## KITTITAS COUNTY COMMUNITY DEVELOPMENT SERVICES

RE: Suncadia Phase 2 Division 5 Preliminary Plat (LP-19-00001) – Transmittal of Comments

**RE:** Suncadia Phase 2 Division 5  
River Ridge II

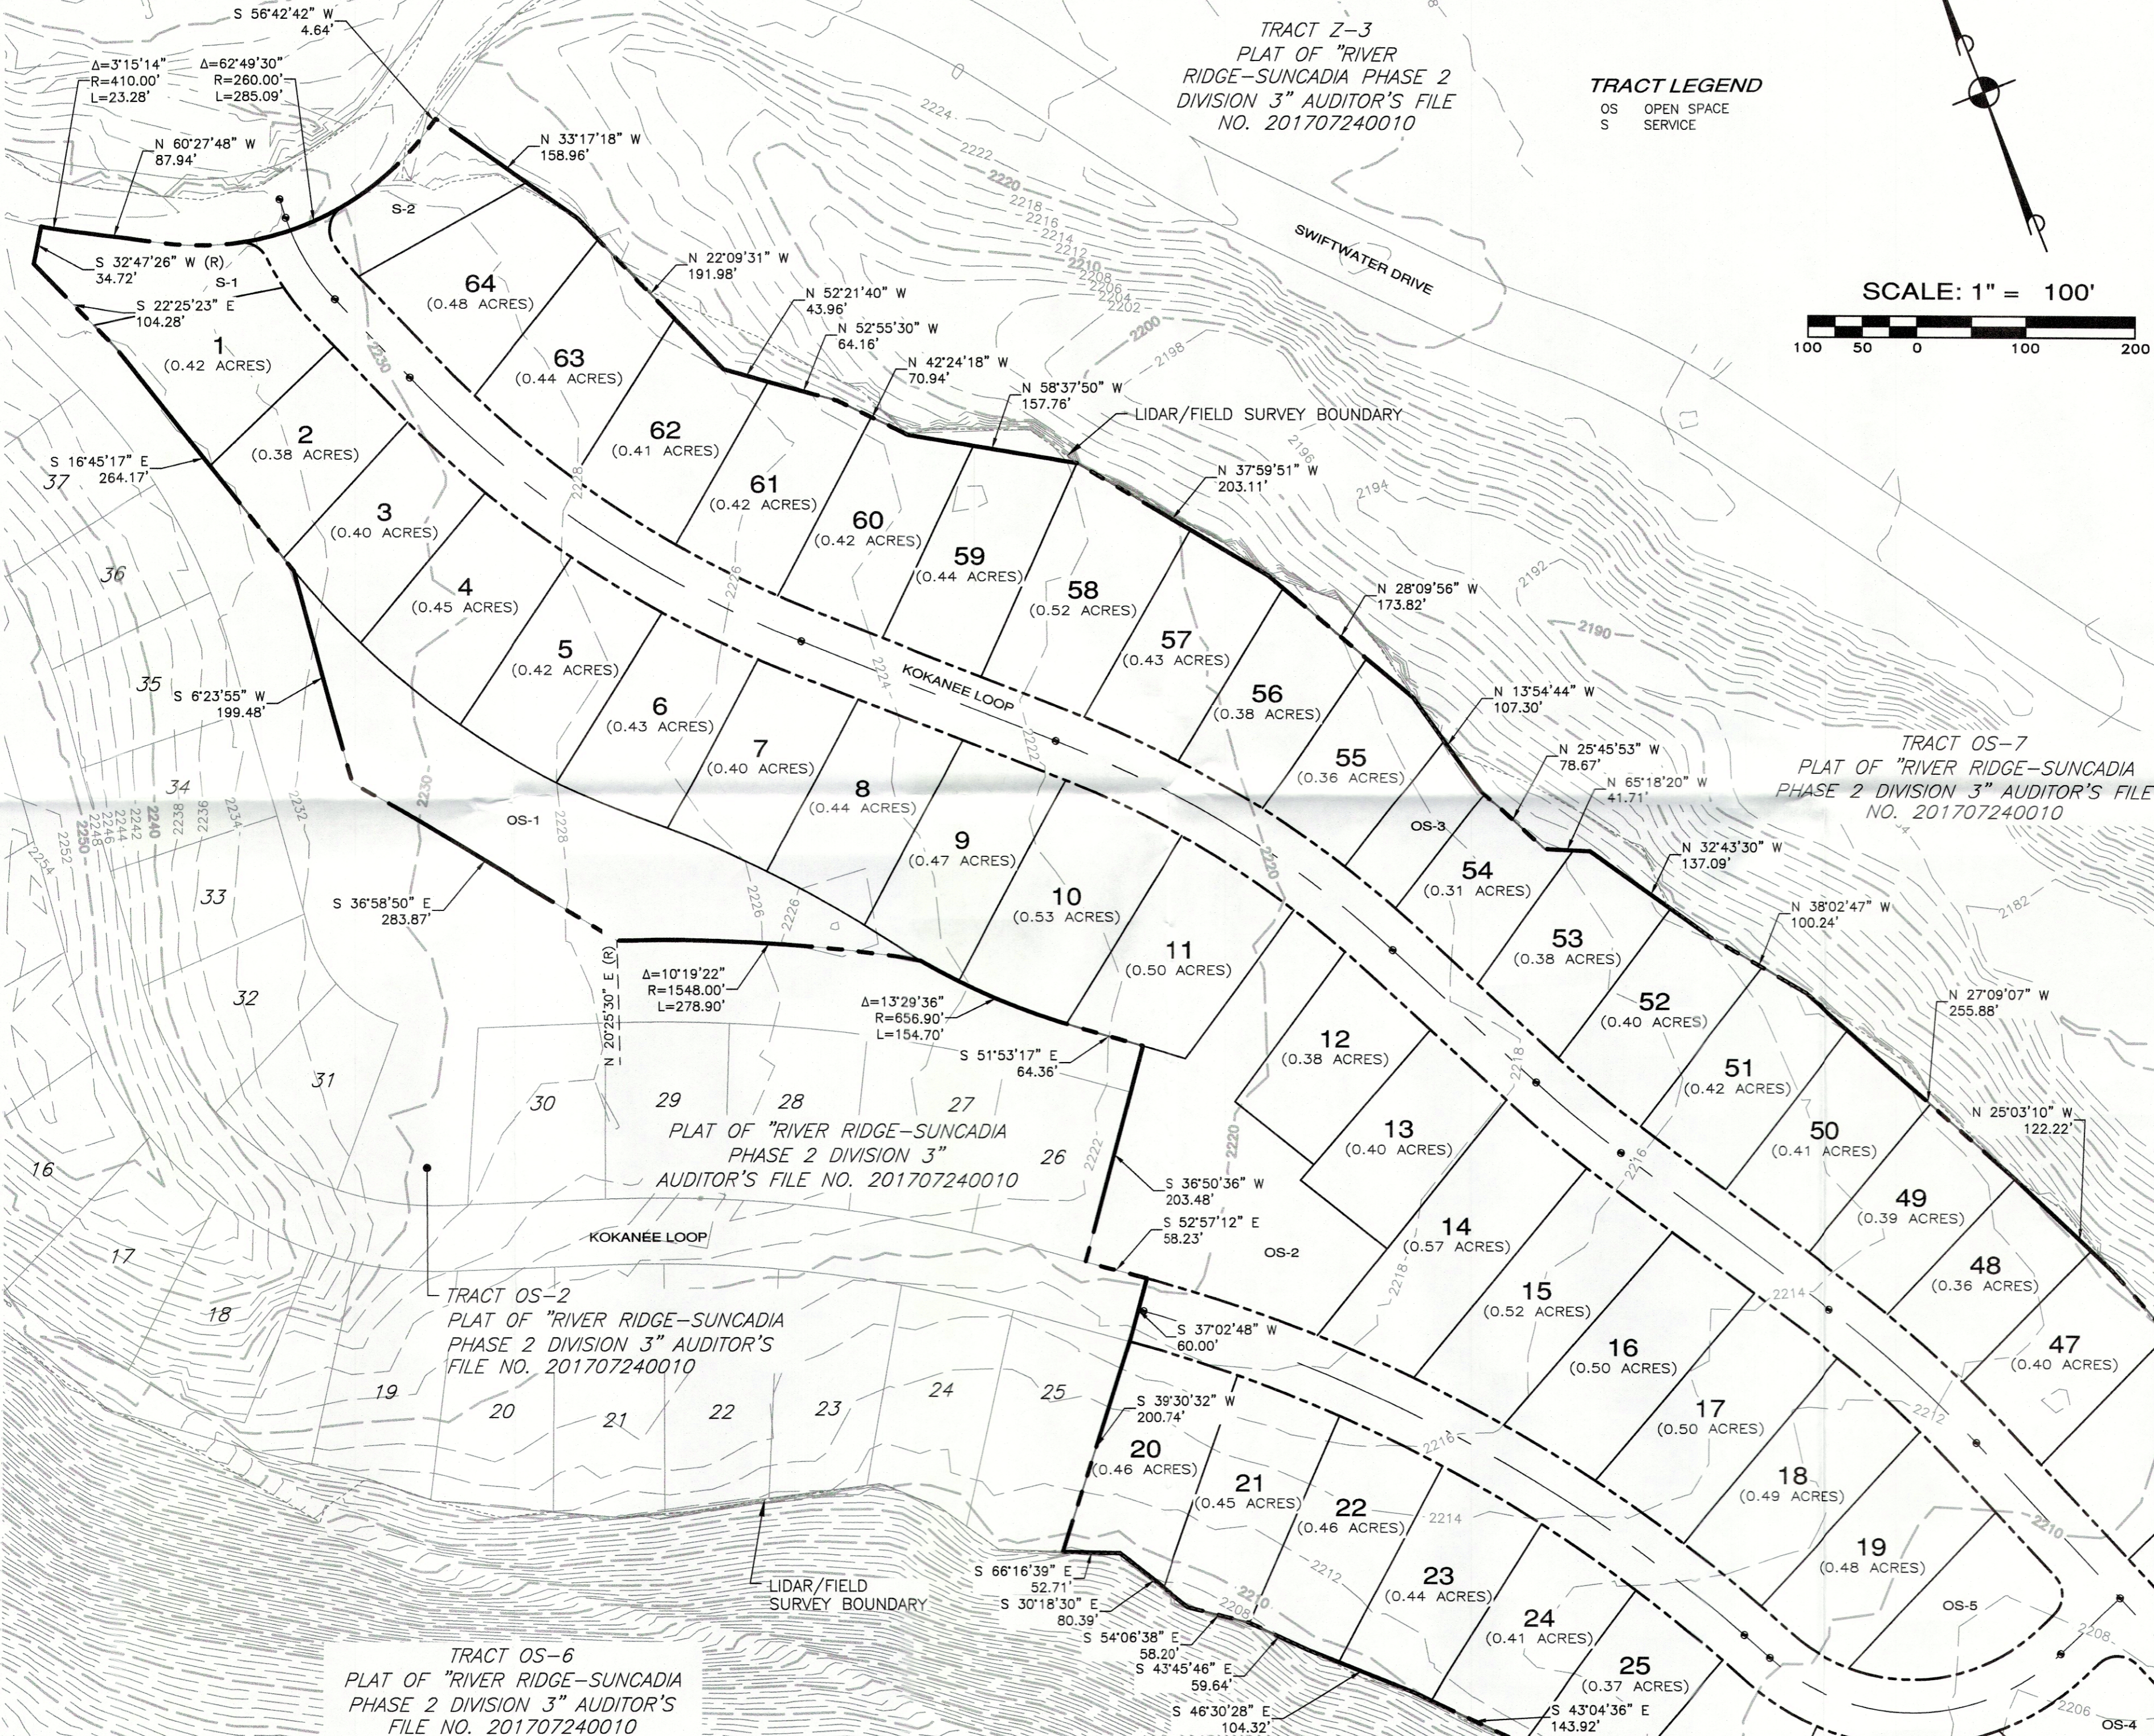
1. Roadway Design
  - A. Please provide profile views for: Kokanee Loop and Kokanee Circle.
  - B. Please provide horizontal curve data for Kokanee Loop and Kokanee Circle.
  - C. Please provide radius data for all intersections.
  - D. Please detail the right of way width on all roadway plan views.

2. Conceptual Utility Plan
  - A. The supplied plan does not provide sufficient detail for substantive utility review.
  - B. The biofiltration swale depicted on lot S-4 appears to be situated immediately up-gradient of a steep slope area. Please affirm that no slope instability is anticipated as a result of the biofiltration swale's proximity to the the top of slope. Similarly, the dispersion path appears to site closely to the top of slope. The proposed dispersion area on lot OS-4 is also close to the top of slope. Please affirm that no bank instability is likely to result from the location of the dispersion areas.

3. Stormwater Plan
  - A. Please provide design calculations for all treatment and disposal areas.
  - B. Please provide disposal rate assumptions supporting all design calculations.
  - C. Please see comments above regarding slope stability concerns.
